PLANNING CONSULTATION RESPONSE

Application No	2025/0984
Proposal	Erection of a two-storey side extension, including under build to rear and the creation of a new access including dropped kerb
Address	75 Rockingham Street, Barnsley, S71 1JS
Date of Consultation Reply	19/12/25
Consultee	Highways DC

SITE PLAN SCALE 1:100

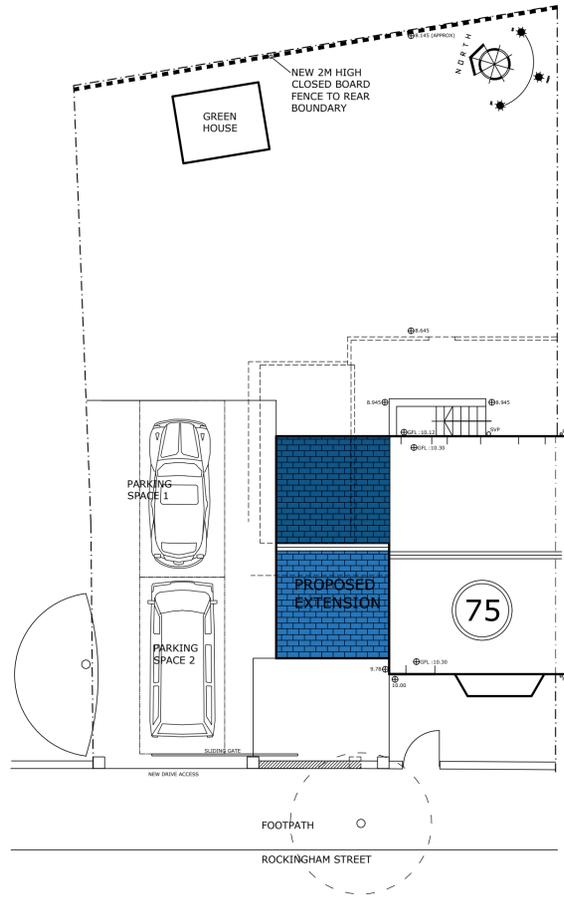
Whilst the proposals increase the floor space of the dwelling with an additional bedroom created, it is intended to install a new driveway space to the side of the dwelling to allow two vehicles to park. The proposed new access moves the entrance away from a mature tree and retains an acceptable level of off-street parking.

The parking facilities as indicated on the submitted plan shall be surfaced in a solid bound permeable material (i.e. not loose chippings) and adequate measures shall be so designed into the proposed access to avoid the discharge of surface water from the site on to the highway.
Reason: To ensure adequate provision for the disposal of surface water and to prevent mud/debris from being deposited on the public highway and to prevent the migration of loose material on to the public highway to the detriment of road safety and in accordance with Local Plan Policy T4 New Development and Transport Safety.
